WEST SUSSEX COUNTY COUNCIL CONSULTATION

TO:	Arun District Council - FAO: Simon Davis
FROM:	WSCC - Highways Authority
DATE:	1 October 2021
LOCATION:	Land at Bayards, Level Mare Lane, Eastergate, PO20 3RZ
SUBJECT:	AL/113/21/OUT Outline application with all matters reserved, apart from access, for up to 69 No dwellings with access, parking, landscaping & associated works. This application is a Departure from the Development Plan.
RECOMMENDATION:	More Information

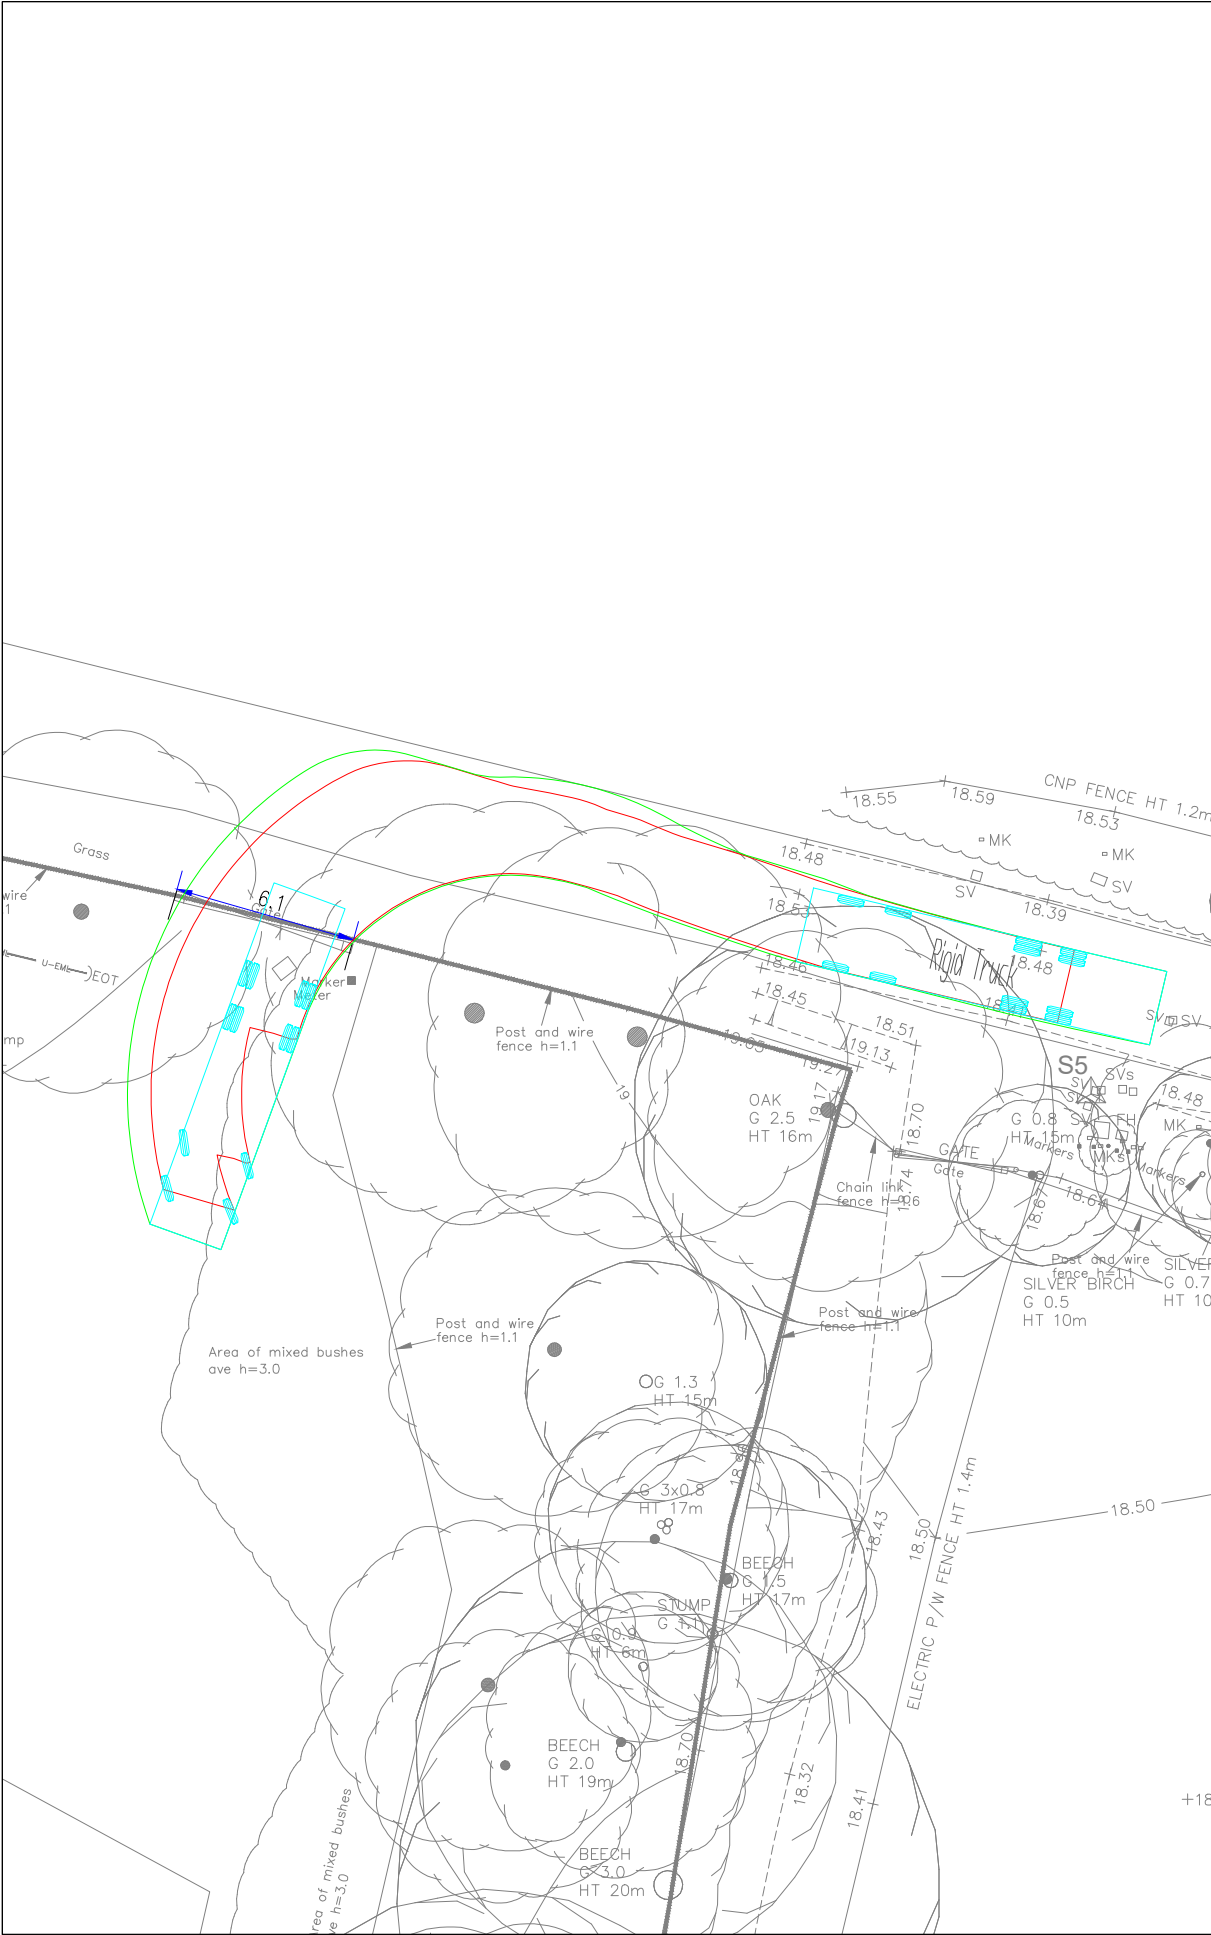
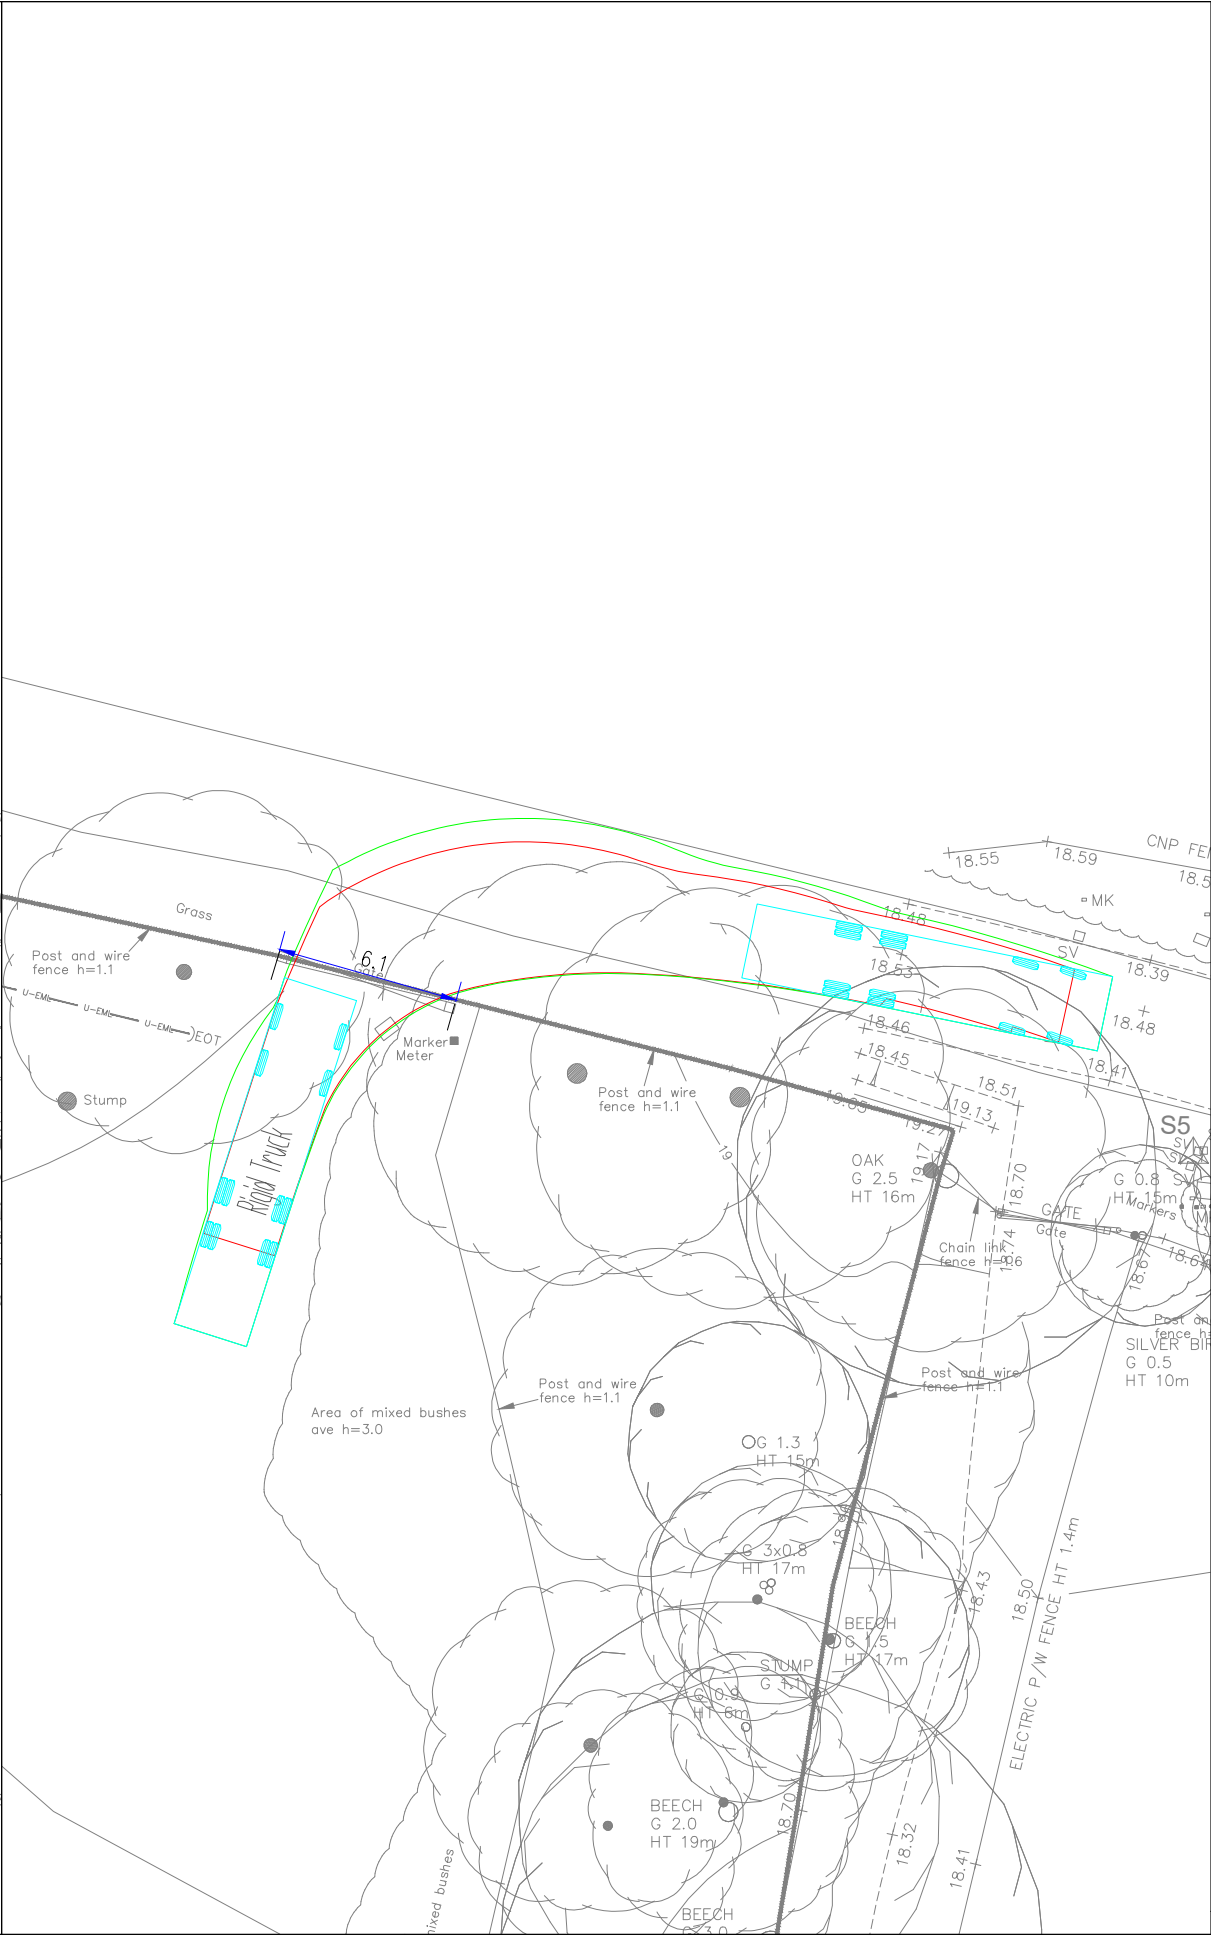
The 6.1m width access will accommodate a largest vehicle of 12m long tipper. Swept path tracking for this has been provided. On site turning should be demonstrated under a finalised site set up plan secured as condition. LHA would also expect the site set up plan to show the areas for parking on site, wheel wash, hoarding, plant

PRIMARY DIRECTION VISIBILITY SPLAYS

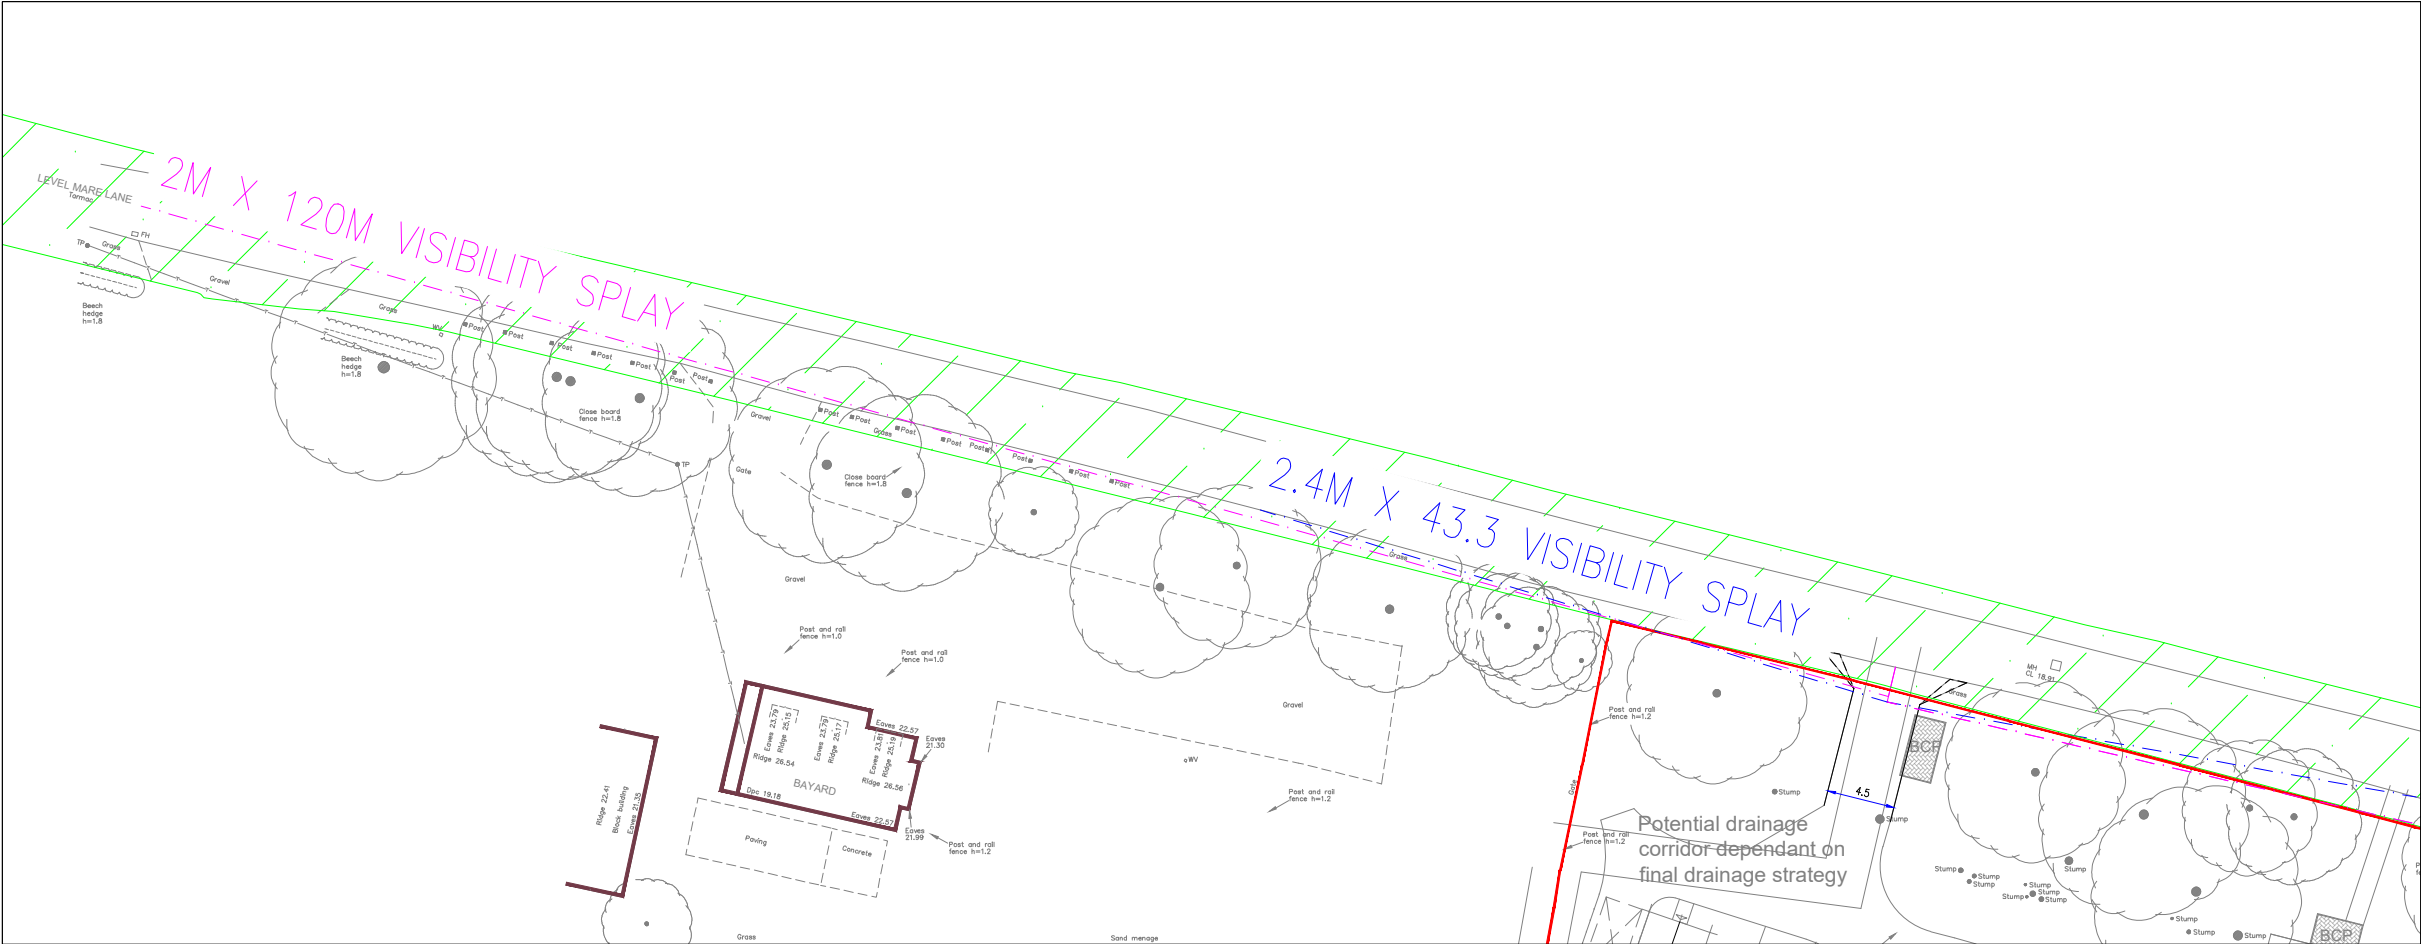
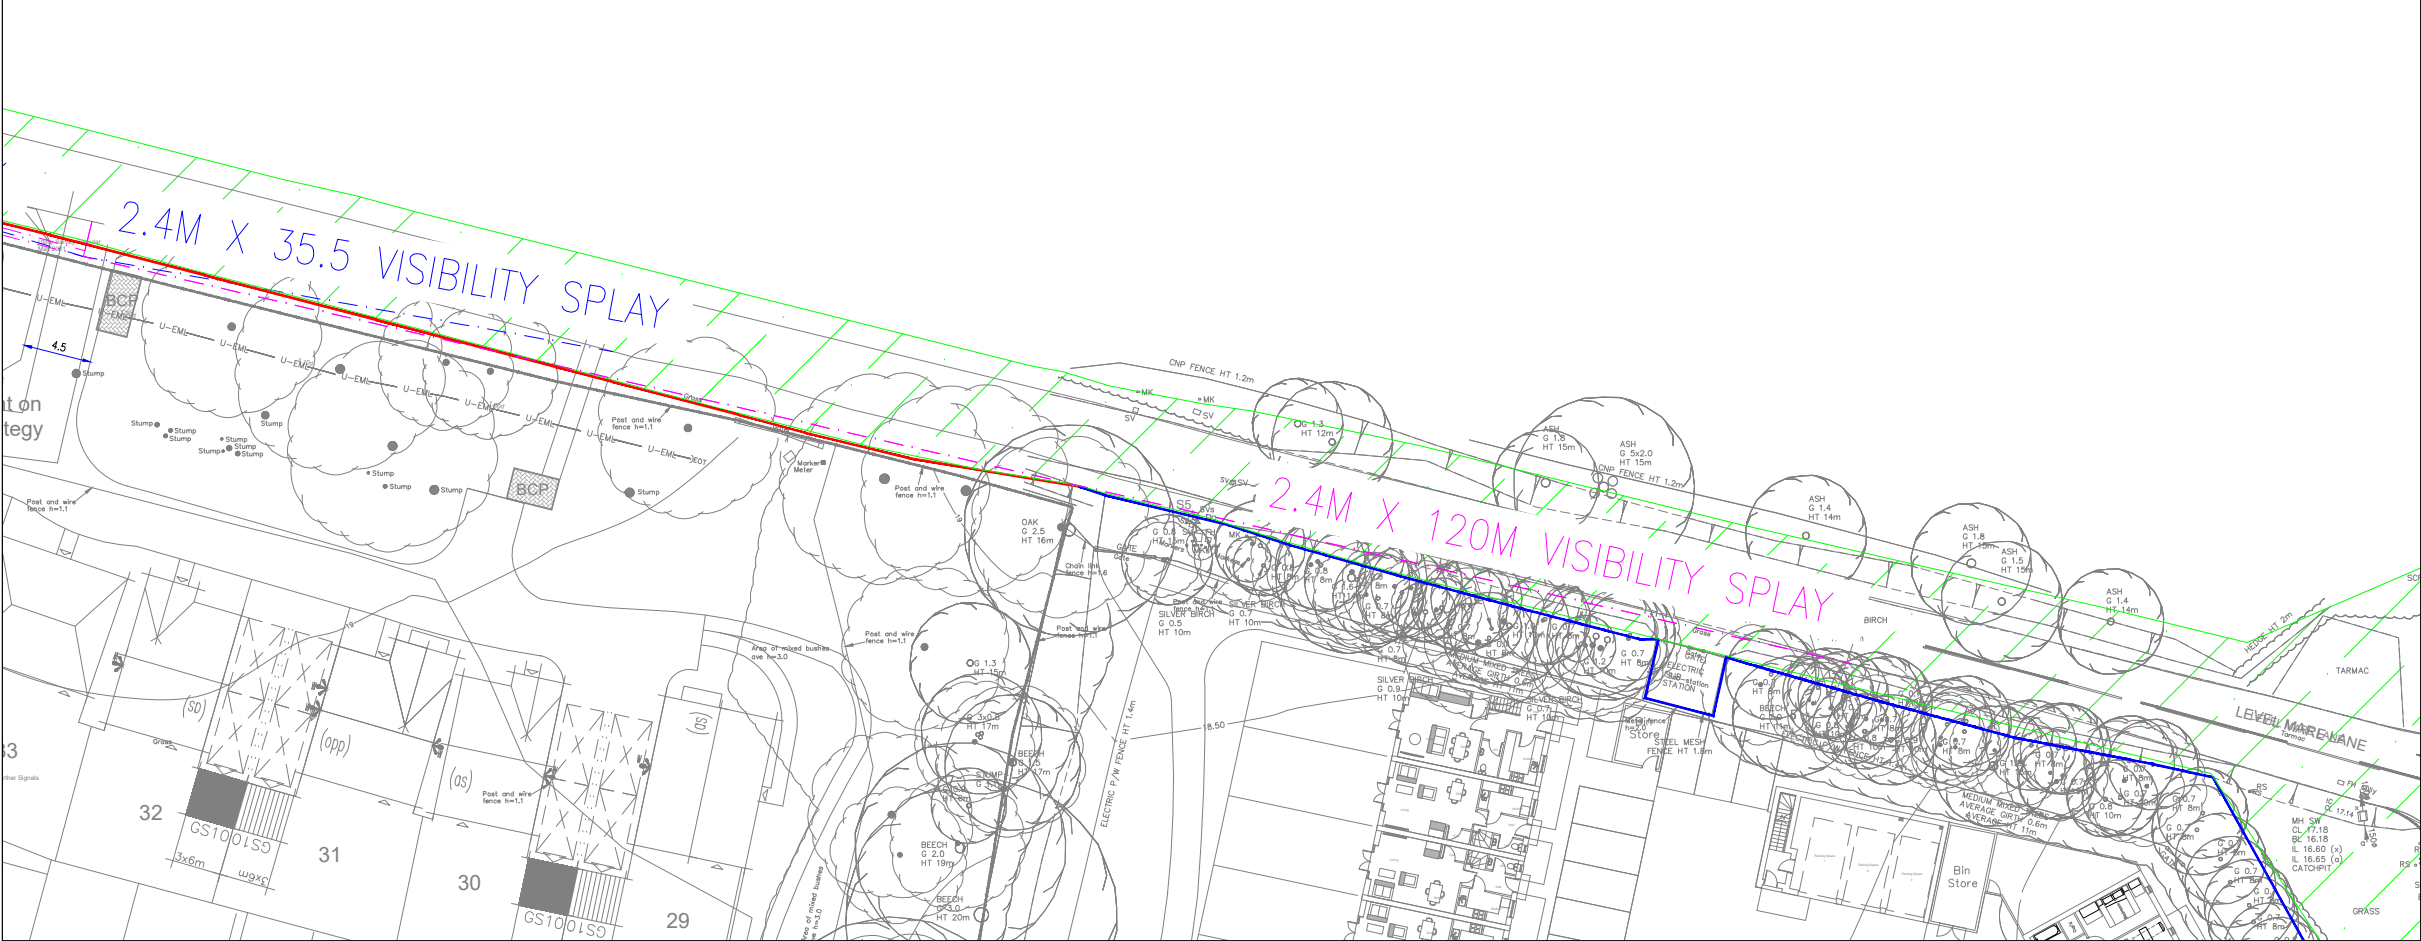
Speed surveys revealed 85th percentile speeds of 30.2mph westbound and 26.2mph eastbound. The location of speed counter was close to the junction with Fontwell Avenue and thus isn't considered representative of eastbound vehicle speeds (west splay) that would be observed from a car exiting the crossover. Furthermore, extent of highway boundary mapping in this location indicates that the 2.4m x 120m visibility splays demonstrated may pass through third party land. Ideally a speed survey at suitable location should be commissioned and amended splays provided although the applicant should first obtain highway boundary

mapping from [REDACTED] and overlay this with the topographical splay drawings and red edge of site to ensure splays are achievable without passing through third party land.

As per comments on Level Mare Lane Access above, the vehicle speeds and achievable splays should be addressed to ensure these are achievable without passing through third party land.

Suitable visibility demonstration at Level Mare Lane access.
